MECKLENBURG COUNTY
Park and Recreation Department

MEMORANDUM

RE: Rezoning Petition #2024-101
PID# 04725215 Additional Parcel Numbers
04725213, 04725214, 04725216, 04725217, 04725218, 04725219

RZ-1.0

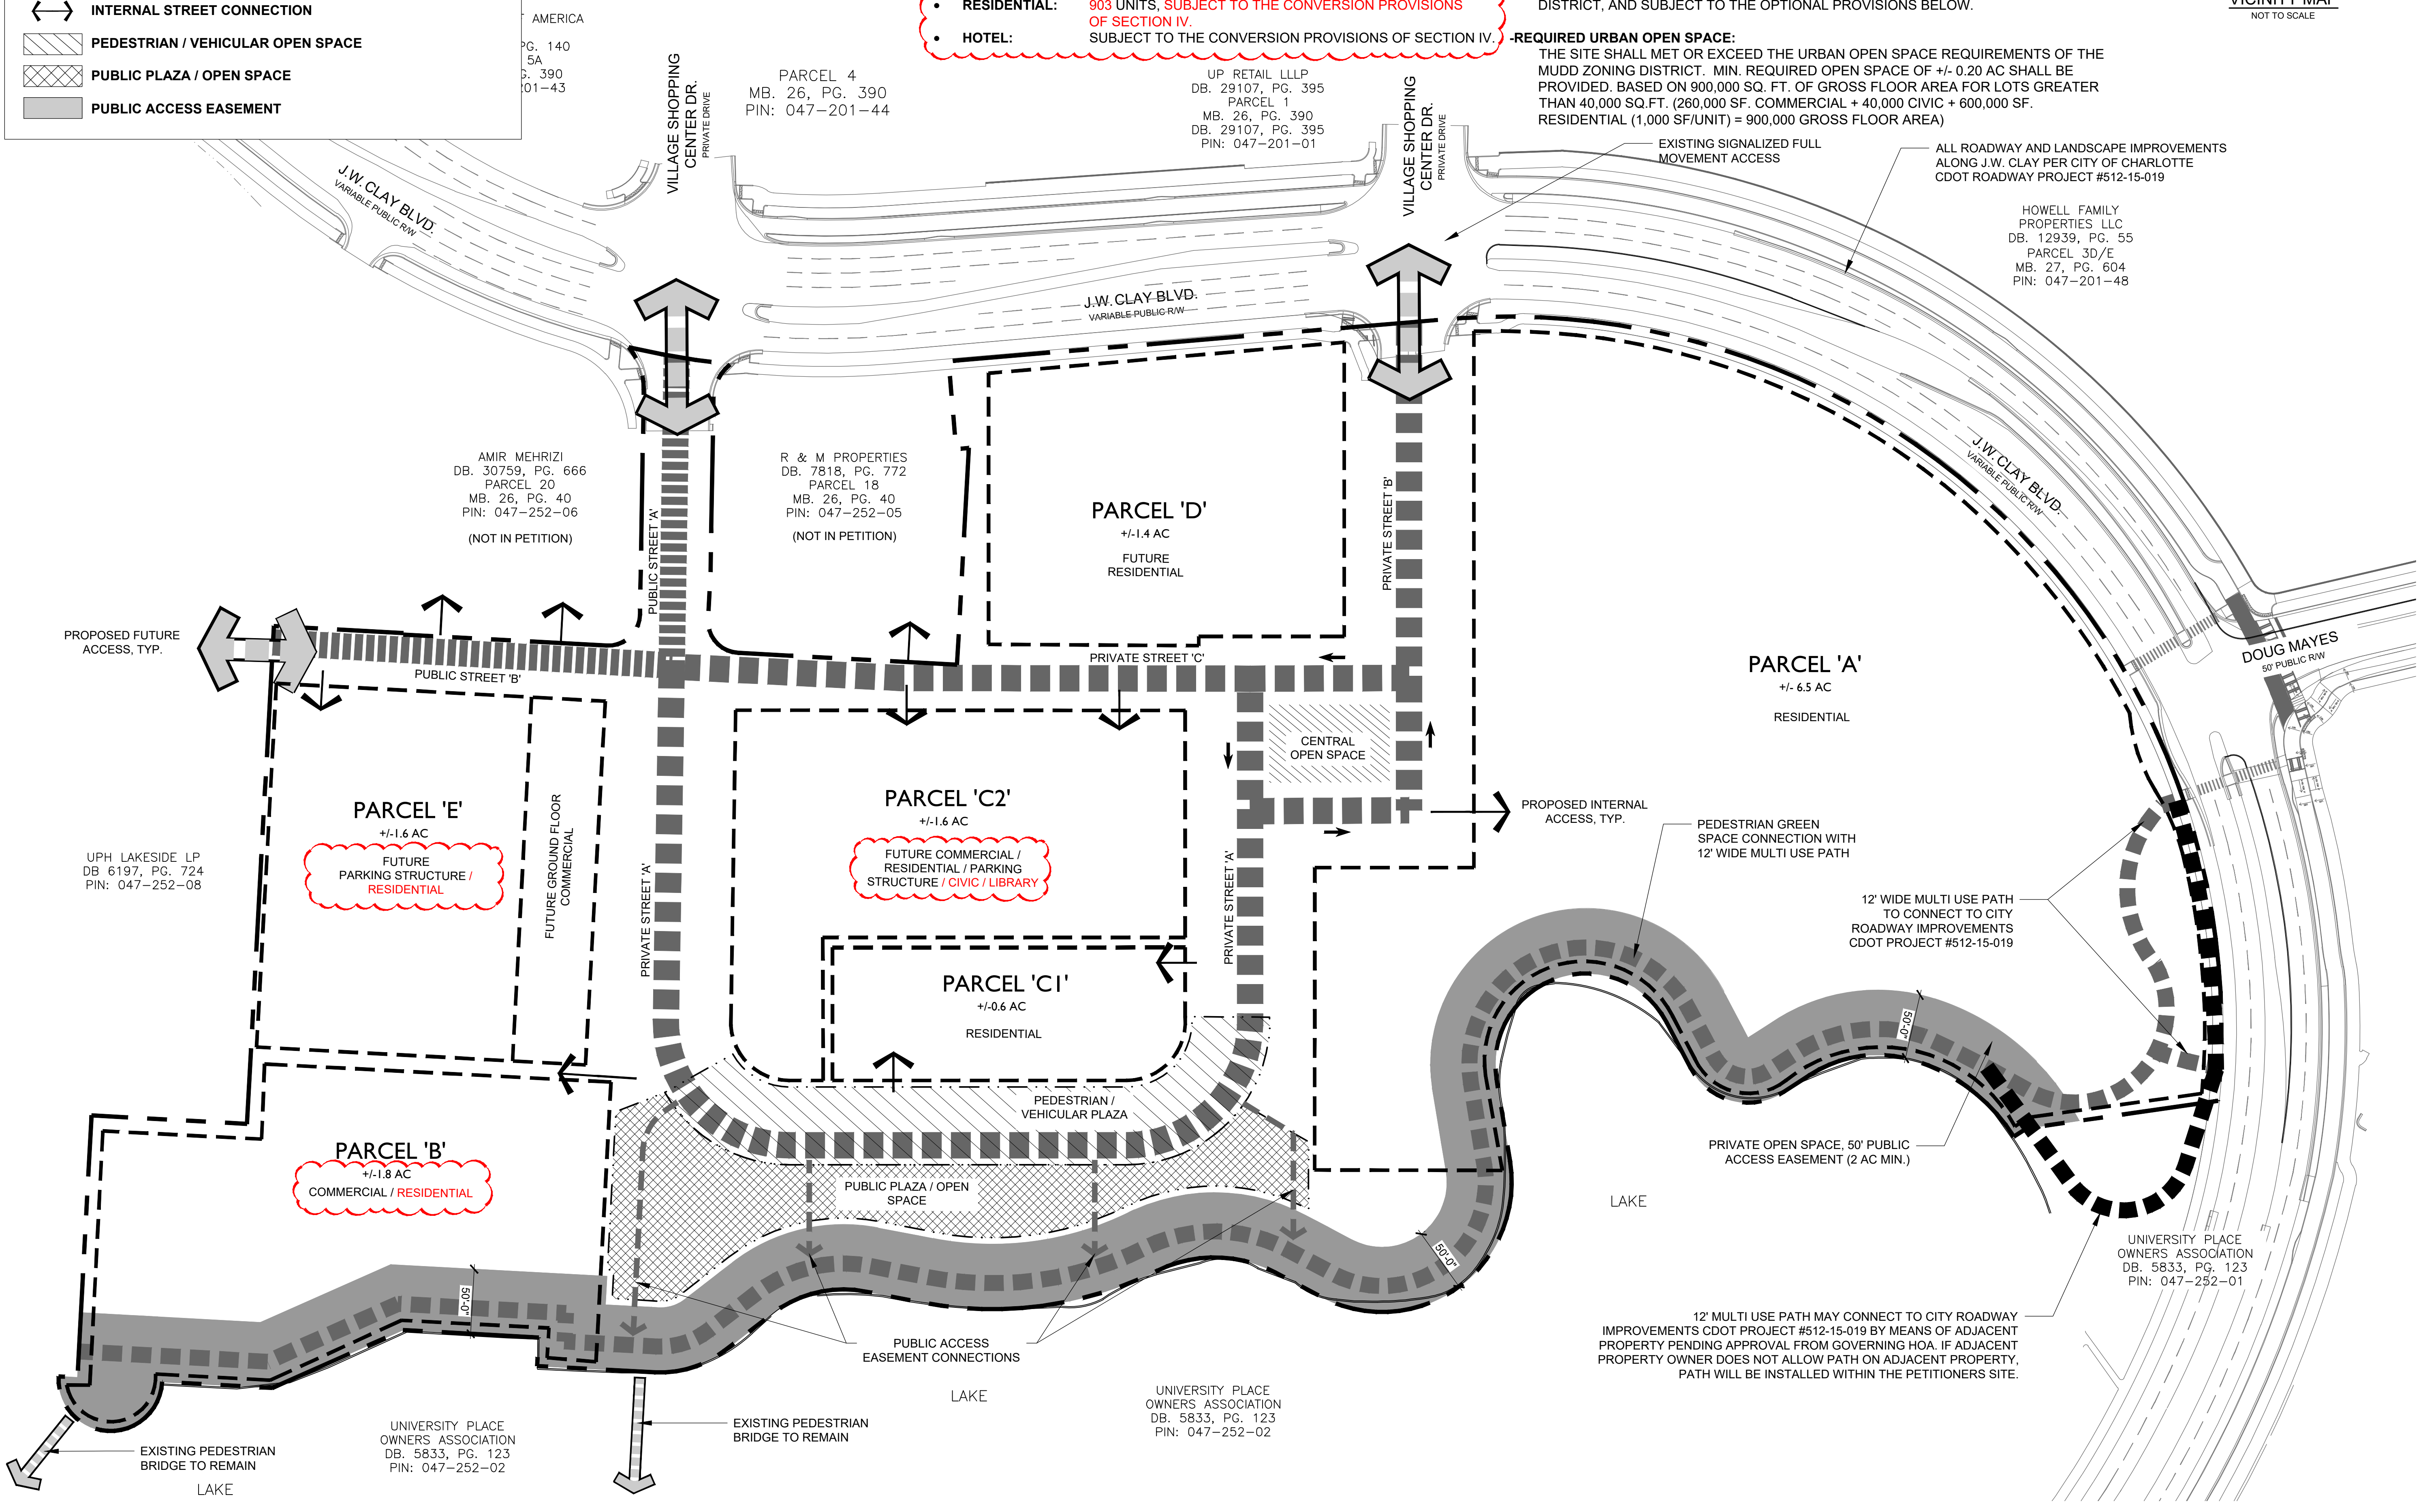
MCPR requests a minimum of 1.0 acres to be dedicated and conveyed to Mecklenburg County for a future neighborhood park. This requested park land shall be adjacent to a public right-of-way for access and is conducive for the development of the typical amenities found in a neighborhood park and cannot include tree save parcels or stormwater BMP's. Dedication to occur at the first C.O.
